Y/45/21/HH & Y/46/21/L

The Chapel Bilsham Lane Bilsham Yapton BN18 0JX

Listed building consent for the partial conversion of existing outbuilding to habitable accommodation (as ancillary accommodation main dwelling).

TYPICAL WINDOW DETAIL @ 1:20 SCALE

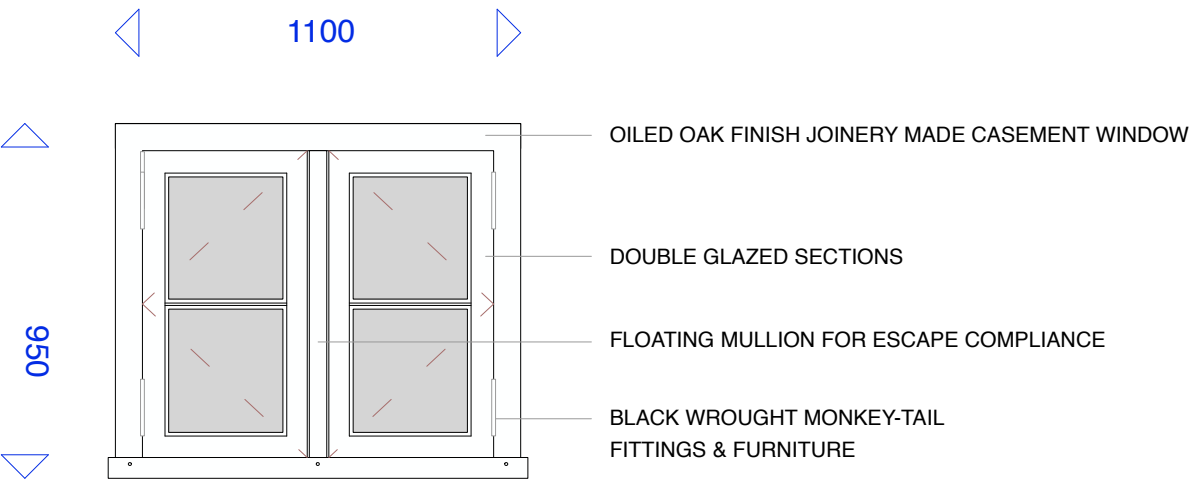
It is recommended that any plumbing should not be visible from the south-west elevation of the main listed building. I note that details of the wooden windows have been provided, which appear to be acceptable.
